RE: Stuart Street
Portland, Maine

Your application to construct a single family modular dwelling has been reviewed and a permit is herewith issued subject to the requirements listed below. This permit does not excuse the applicant from meeting applicable State and Federal laws.

REASON FOR PERMIT: To install a single family modular home

RE: Request for Certificate of Occupancy
21 Stuart Street

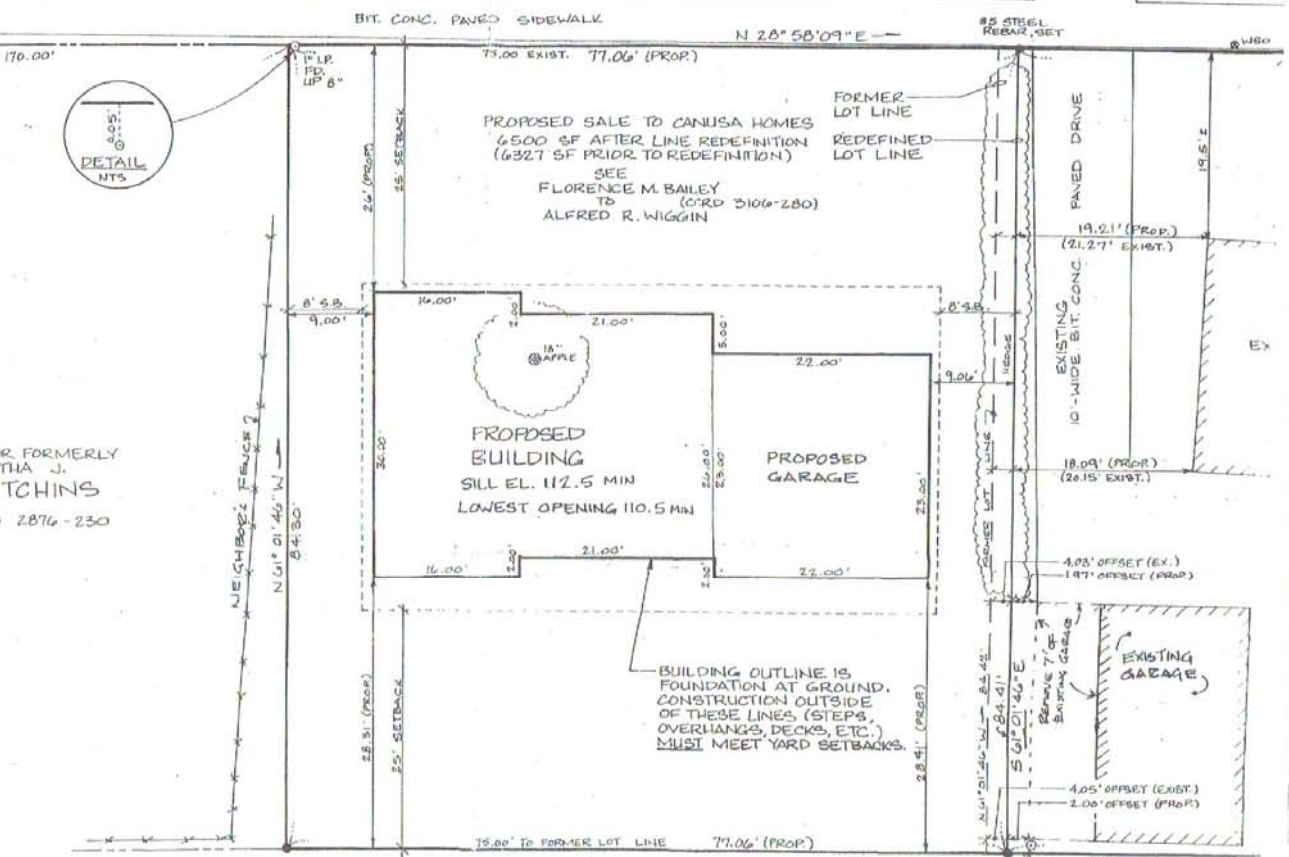
2. The site plan must be updated to show the locations of the services as well as the location of the foundation drain as specified in conditions 5 and 13.
